# **KIRKLEES METROPOLITAN COUNCIL INVESTMENT & REGENERATION SERVICE**

### **DELEGATED DECISION TO DETERMINE PLANNING APPLICATIONS**

| Reference No:         | <b>2026/62/91324/W</b>                                                        |
| Description:          | Erection of two storey side and single storey rear extensions and alterations |

Drawing	Plans as proposed	Rev.	X B
Job No.	Drawing No.		
	2

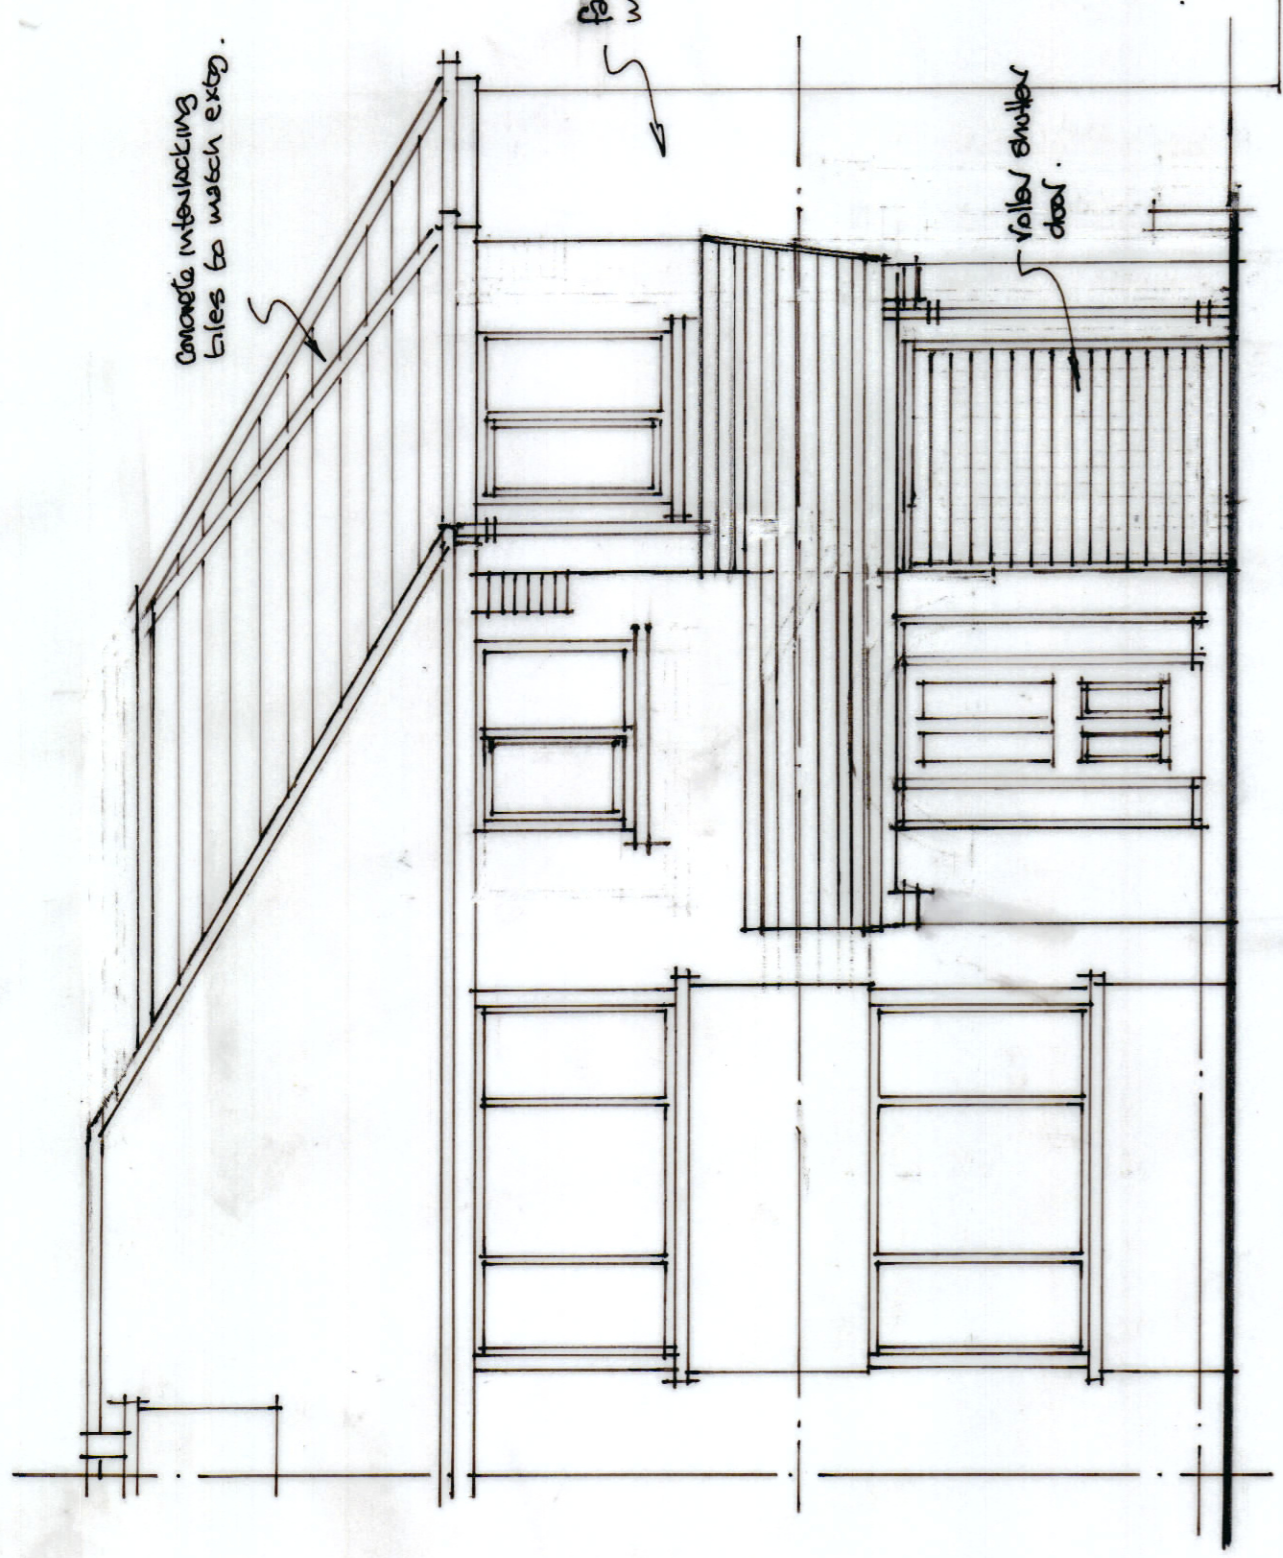
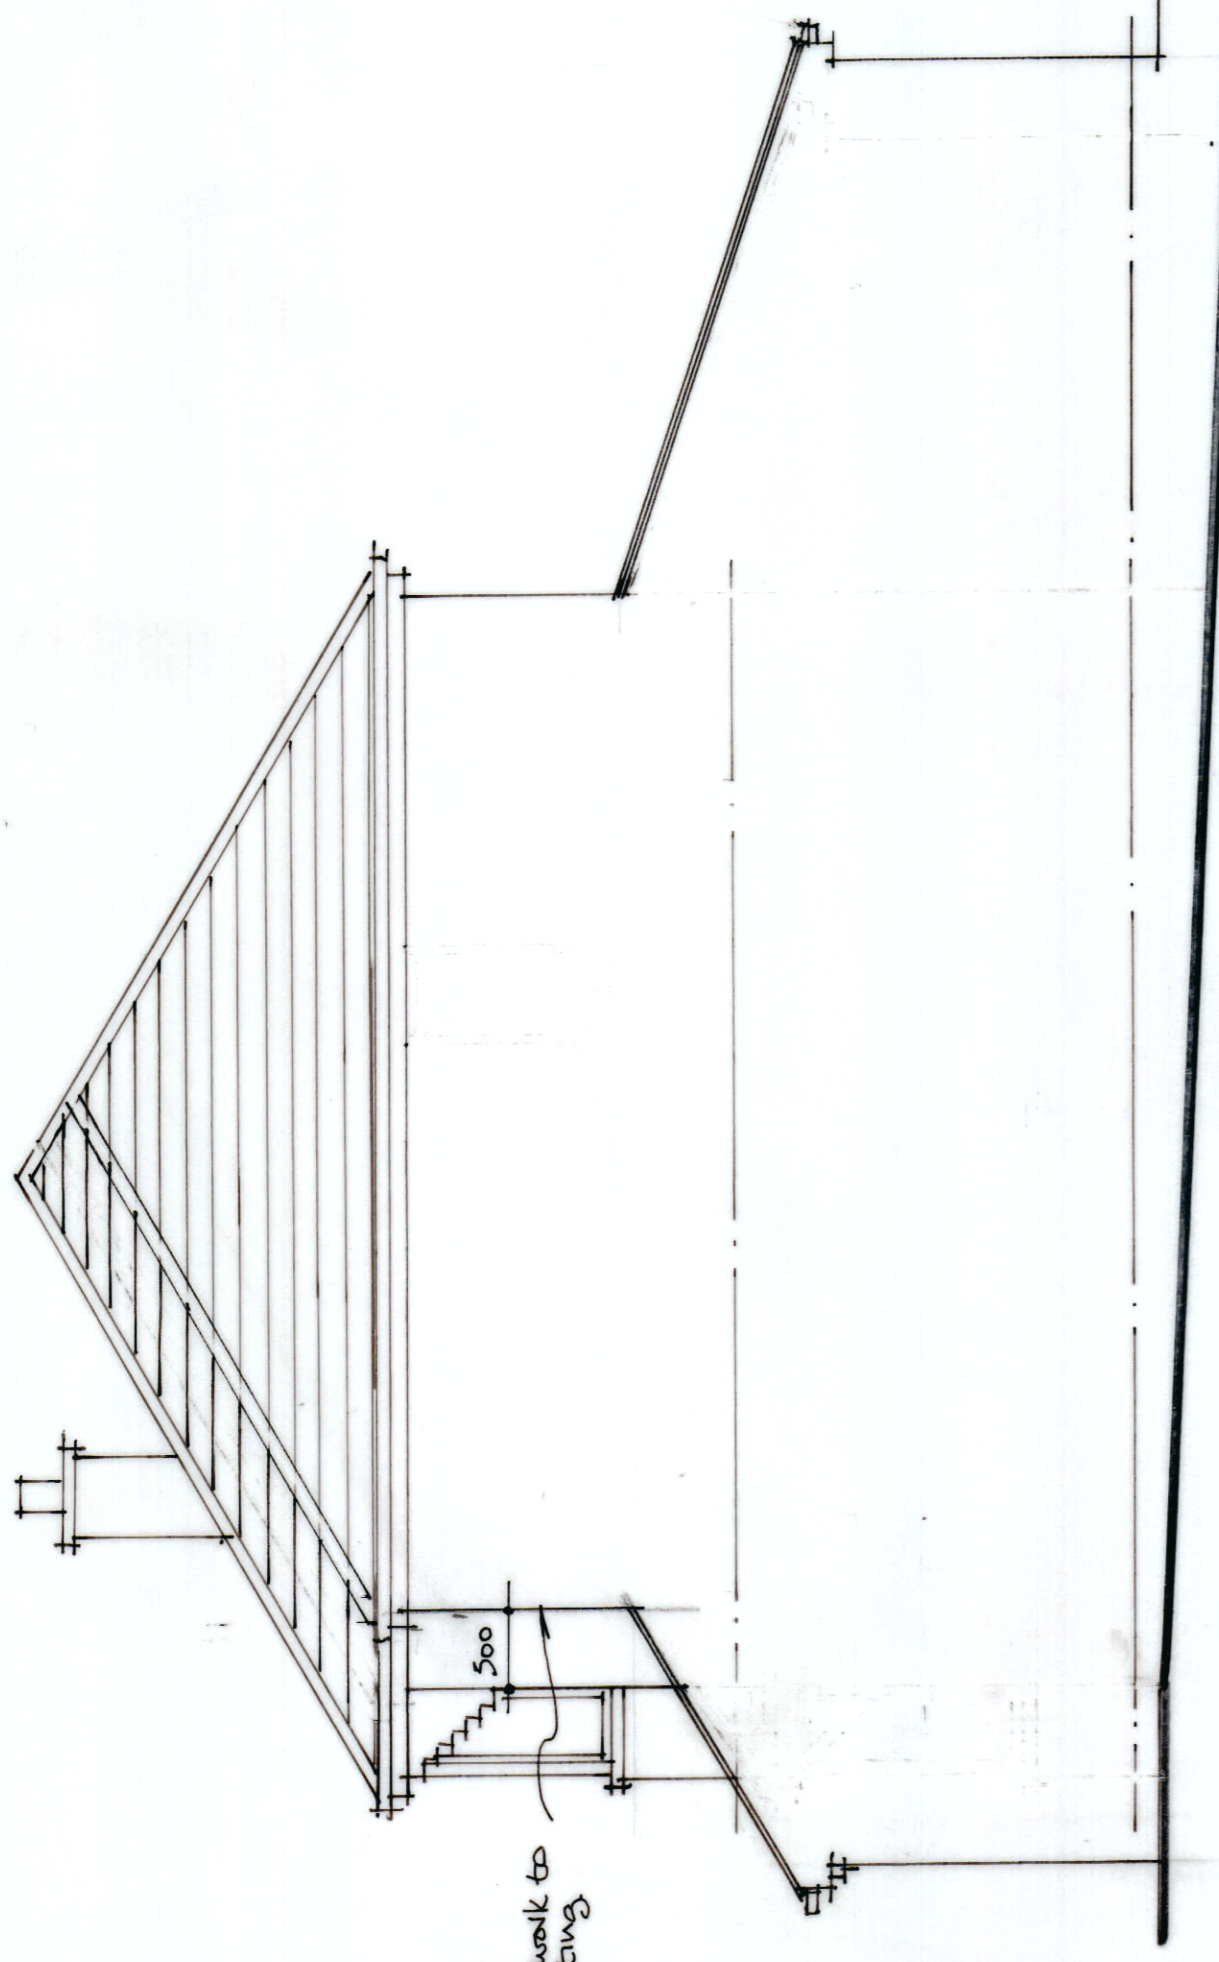
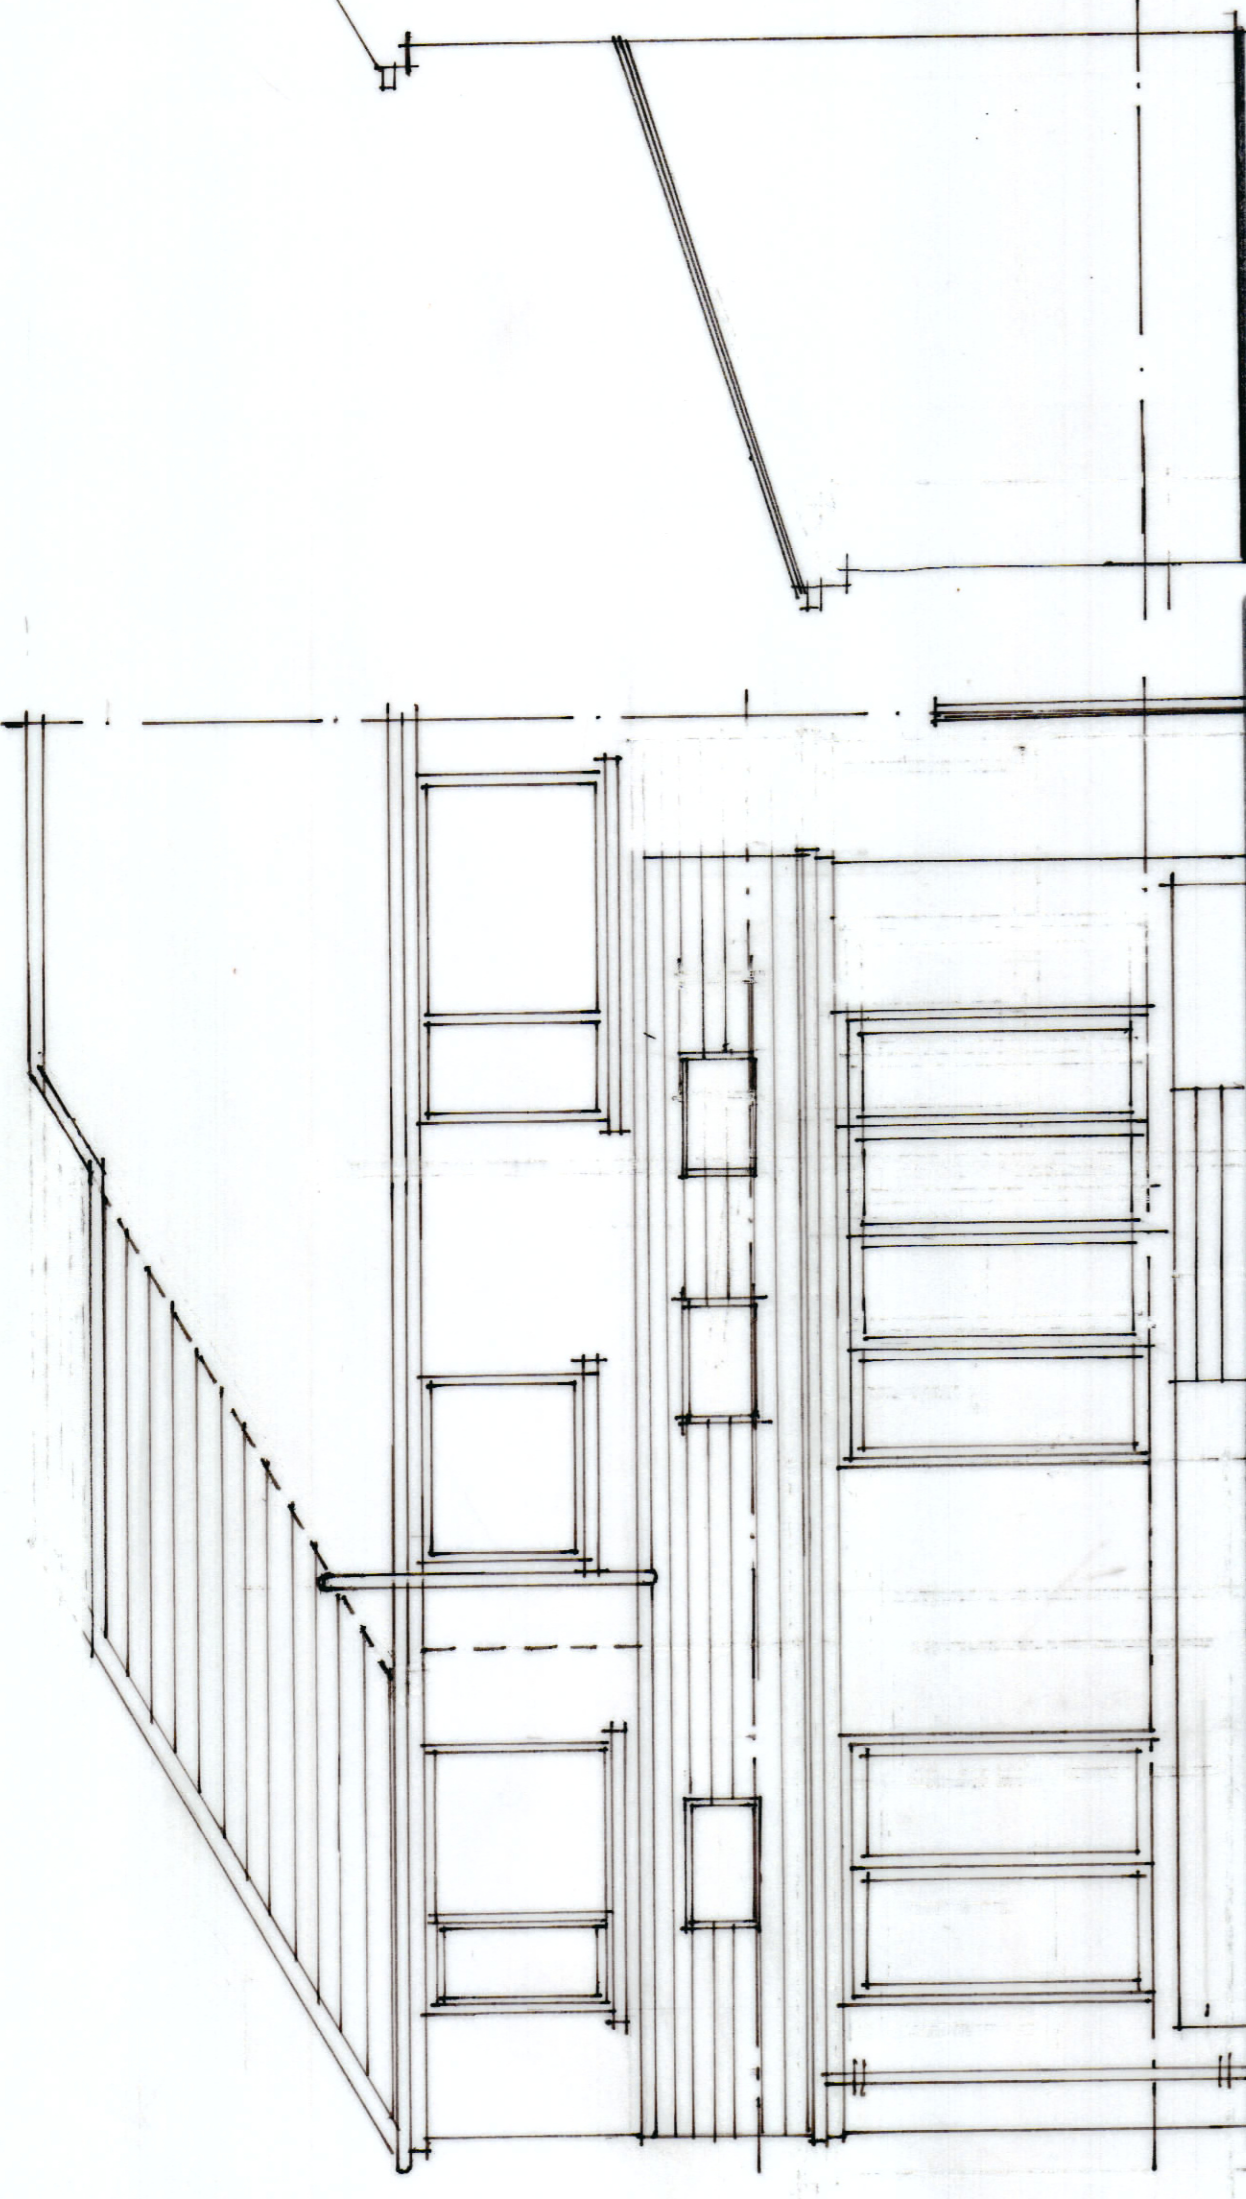
The proposed side extension would occupy the majority of the existing gap between the host dwelling and the side boundary, leaving a separation distance of approximately 0.2m. It is acknowledged that the spacing between dwellings is a defining characteristic of this section of Thorpe Green Drive, contributing to the open and spacious appearance of the street scene. Consequently, the proposal would result in the loss of much of the existing gap to the side of the property and would inevitably reduce this sense of openness.

The extension would be constructed with a hipped roof set below the ridge line of the existing dwelling, which would reduce its overall bulk and ensure it remains visually subordinate to the host property. In addition, amended plans have secured a first-floor set back of approximately 500mm from the front elevation, further creating a subordinate appearance of the extension in accordance with the Council's Extensions SPD.

The proposed two-storey side extension would be positioned adjacent to the side driveway of No. 18. Due to its two storey scale and massing, the extension would inevitably result in some degree of overbearing impact on this side driveway and windows of No.18. During the site visit, it was observed that the development would be situated approximately 3m from the ground-floor side entrance door and a first-floor side window serving No. 18. However, the first-floor window is relatively small in scale and is considered likely to serve a landing or other non-habitable space, rather than a primary habitable room.

The submitted plans confirm that no windows are proposed within the side elevations of the extension. Consequently, the development would not give rise to any unacceptable overlooking or loss of privacy for the occupants of No. 18.

Kirklees Council Highways Development Management has been informally consulted during the assessment of the application. In light of the increase in the number of bedrooms and the associated parking demand, officers have reviewed the proposed parking arrangements. The entire front curtilage would be hard surfaced, providing an area of approximately 7.5m in width by 5.5m in depth. Officers consider this to provide sufficient space to accommodate three off-street parking spaces, in accordance with the guidance set out in the SPD.
